## Response to Planning application from Hertfordshire County Council (T and CP GDP Order 2015)

District ref: 6/2024/0858/COND  
HCC ref: WH/20994/2024  
HCC received: 14 May 2024  
Area manager: Manjinder Sehmi  
Case officer: Samuel Tearle

Beadles Volkswagen Van Centre Harpsfield Broadway Hatfield AL10 9TF

Submission of details pursuant to condition number Condition 1 (Construction Management Plan), 6 (Surface Water Drainage Scheme) and 9 (Proposed Roads, Footways and Cycleways) on planning permission 6/2020/3222/MAJ

Drawing Number
HAT-RDB-XX-XX-DR-A-0033

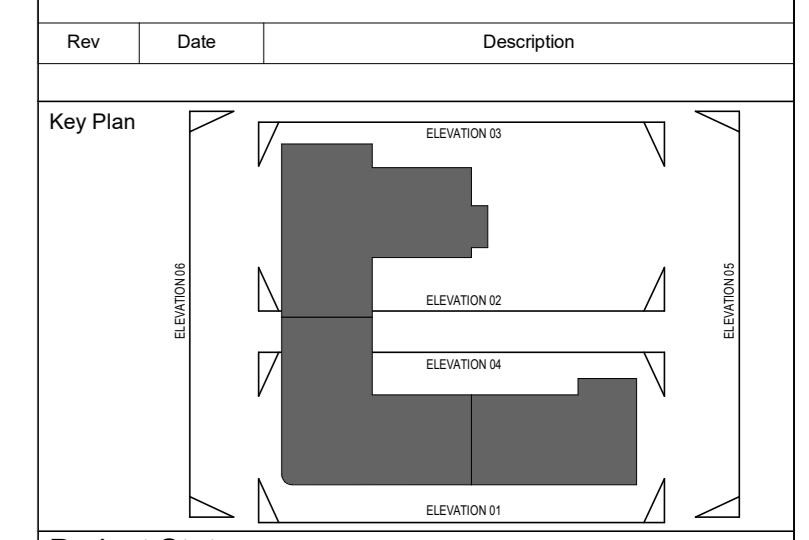
To support the discharge of condition, the applicant has submitted Drawing No. DR-A-0033 Rev -. It is noted that this drawing only shows the areas within the site, and the red line boundary shown is not recognised / acknowledged for the sections which appear to be public footway/cycleway and the access.

A review of DR-A-0033 Rev shows landscaping along the boundary, and it is unclear whether a 3m shared facility can be achieved for the full length. Therefore, the Highway Authority wishes to raise an objection to the discharge of Condition 09 until further clarity is provided.  
(see Condition 11 comments of application 6/2024/0859 for additional details).
